**Our Case Number:** ABP-314056-22

**Re:** Liffey Valley to City Centre Core Bus Corridor Scheme.  
Fonthill Road to High Street all in the County of Dublin.

## SUBMISSION ABP LIFFEY VALLEY SCHEME

Programme Title: BUSCONNECTS DUBLIN CORE BUS CORRIDORS INFRASTRUCTURE WORKS			
Drawing Title: LIFFEY VALLEY TO CITY CENTRE CORE BUS CORRIDOR SCHEME TRAFFIC SIGNS AND ROAD MARKINGS			
Drawing File Name: BCIDB-JAC-TSM_GA-0007_XX_00-DR-CR-0024	Sheet Number: 24 of 28	Status: A	Rev: M01

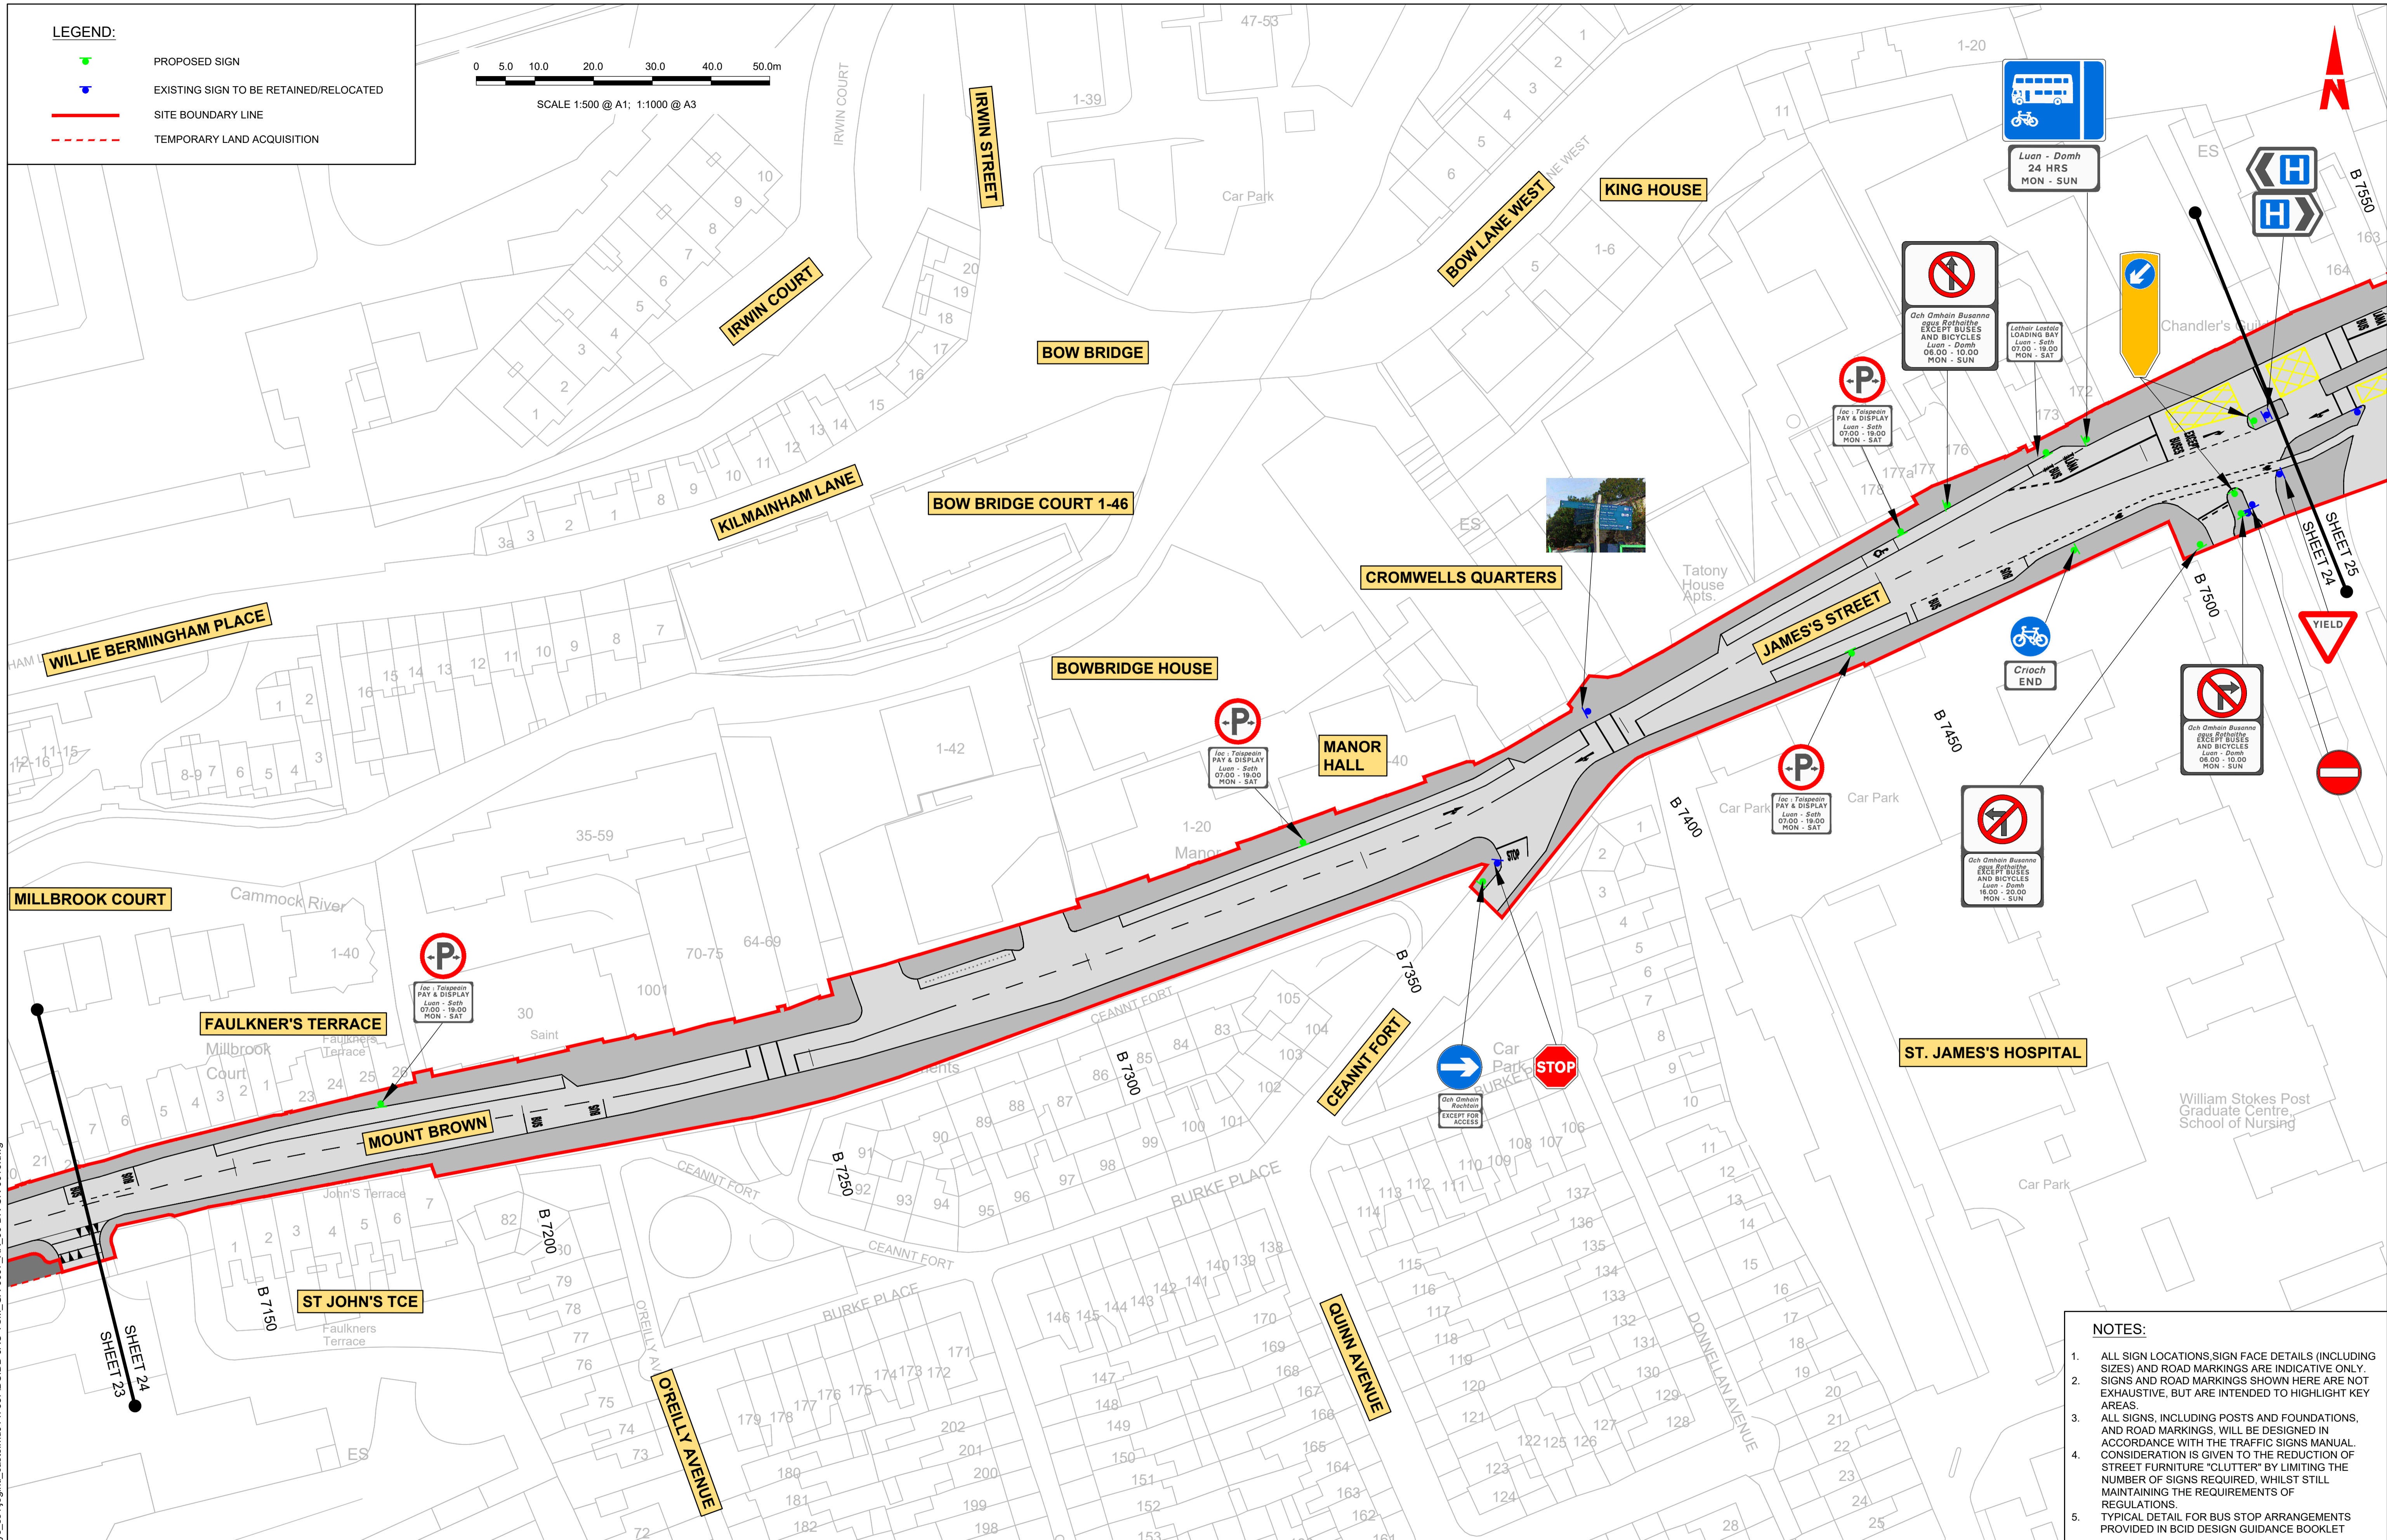
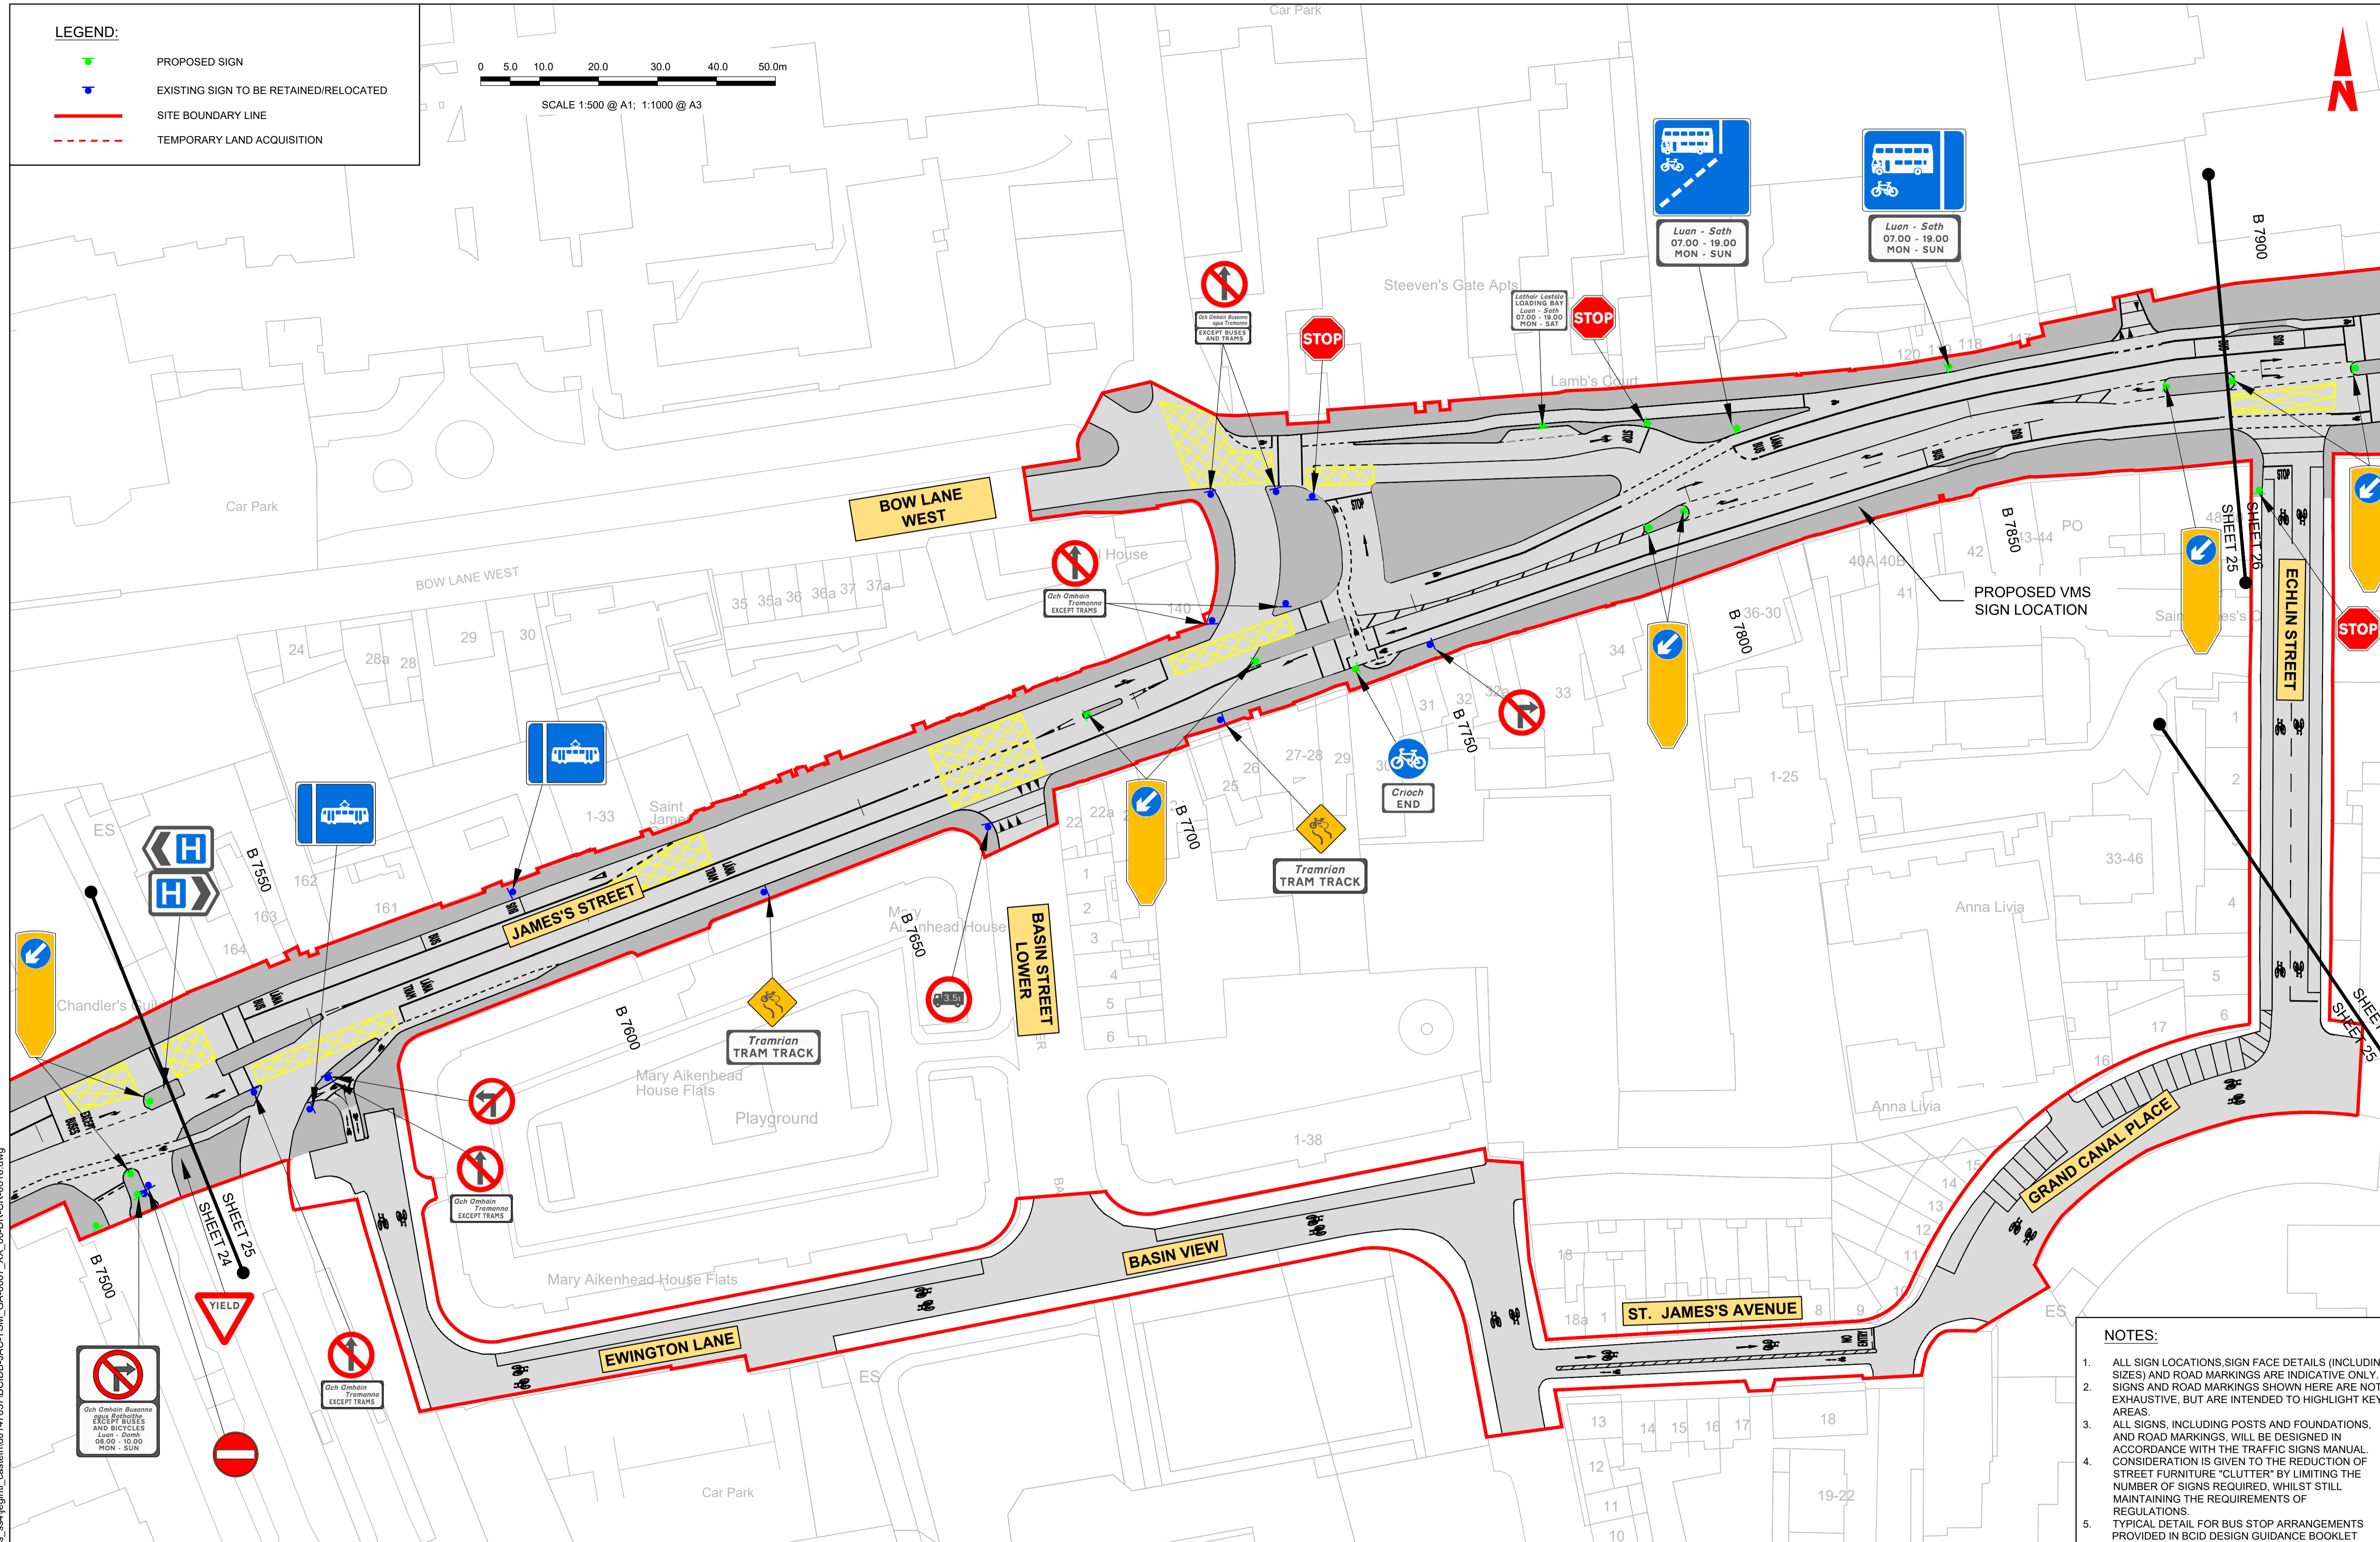
The maps at "General Arrangement" maps 24 and 25 of 28 indicate that there is to be a bus gate at James's Street at the entrance to St James Hospital. The suggested operation times are very difficult to read, with a crazy small print size for a really important bit of information.

However it seems the proposed hours are

06.00 to 10.00 Monday to Sunday city bound except buses and bicycles

16.00 to 20.00 Monday to Sunday Kilmainham bound except buses and bicycles although it may be that this applies to a left turn ex the Hospital only

As I had a discussion with Mr Cregan of BusConnects in the context of bus lanes about 07.00 being too late and 19.00 being too early for these to expire. I would broadly favour the 06.00 and 20.00 concepts. In particular a 06.00 to 10.00 stops commuter traffic easily accessing the city in the morning and therefore it is simply not there to return in the evening. However I think there is zero justification for any ban at 06.00 to 10.00 on Sunday. I also believe that other bans on both Saturday and Sunday should not be permitted, although I would concede that Saturday evenings can be problematic.

I would be concerned that the Bord should not confuse the hours of operation of bus lanes, where there is another lane open to general traffic and bus gates where general traffic has to take a long diversion. At quiet hours the traffic can drive in the general lane, so there is no benefit being able to drive in the bus lane.

I would also ask you to consider whether any PM ban is required at all in the light of my observations on time saving.

I think it should be a specific condition of the planning consent that these hours of operation cannot be extended without seeking further specific planning approval.
